Application Number: S6/2012/1142/FP

Address: 8 Wilkins Green Lane  
Hatfield

Comment: Re; planning application S6/2012/1142/FP 9, Wilkins Green Lane, Hatfield As the occupant of no 8, I wish to supplement my previous objections.

SIDE ELEVATION FROM No8

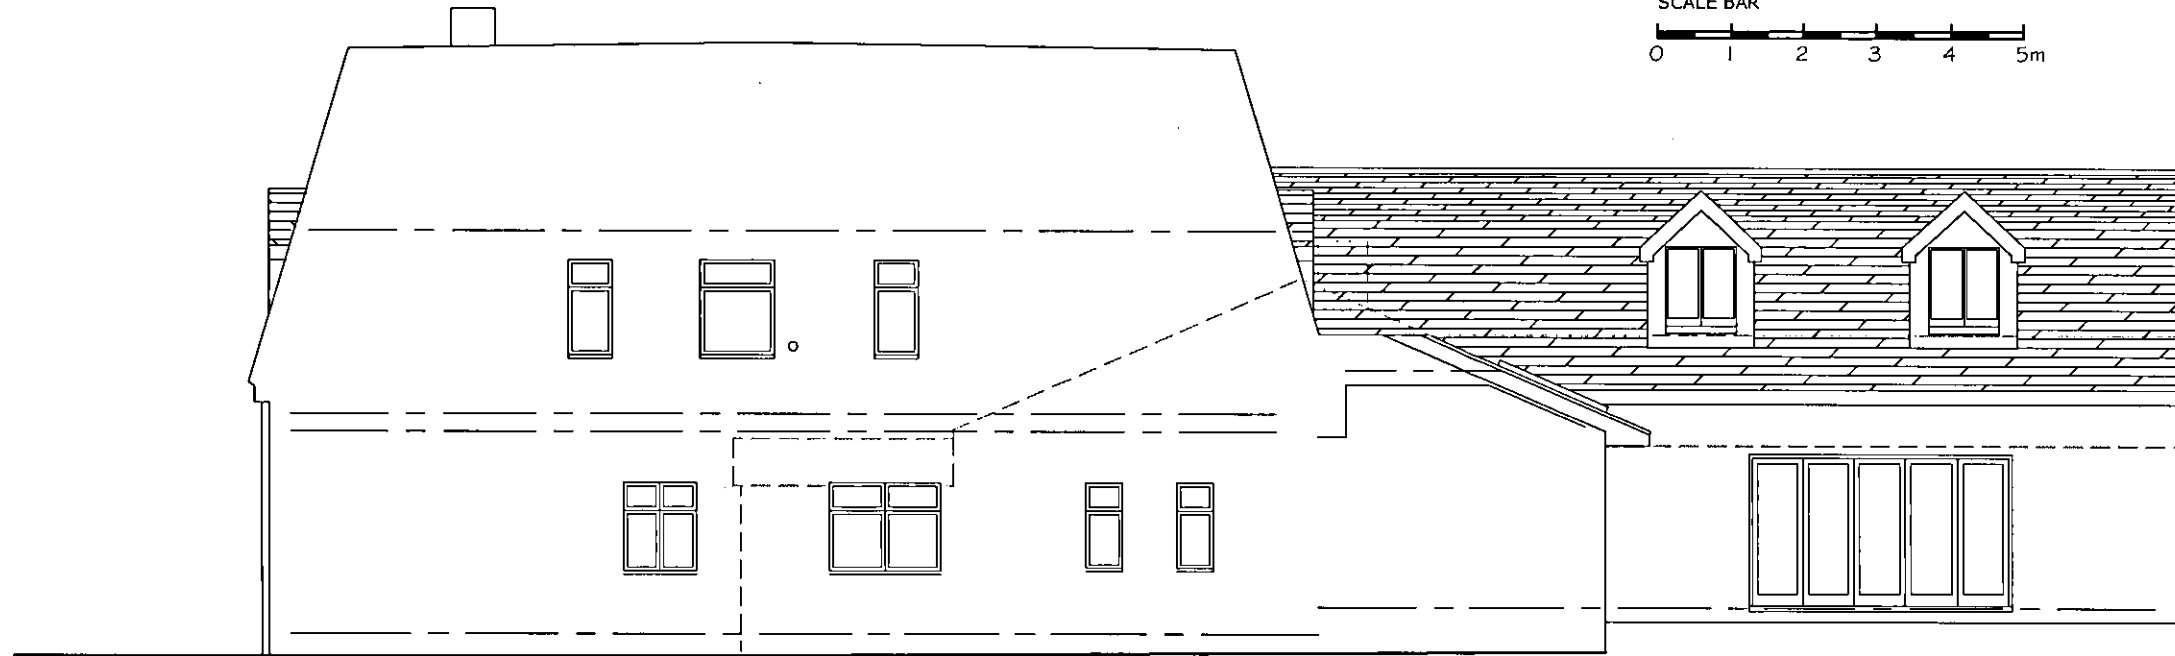
&#8226; The proposal involves a 3 storey vertical wall adjacent to my boundary, reaching to the same height as the ridge line of my house.

&#8226; The proposed wall would extend from the front of my house beyond the back, blocking a gap where currently we get some early afternoon sunshine and light.

&#8226; Afternoon and evening sun would be cut off from one of our bedrooms.

&#8226; There would be no possibility of our shielding the new wall by trees, because it is adjacent to the path beside our house.
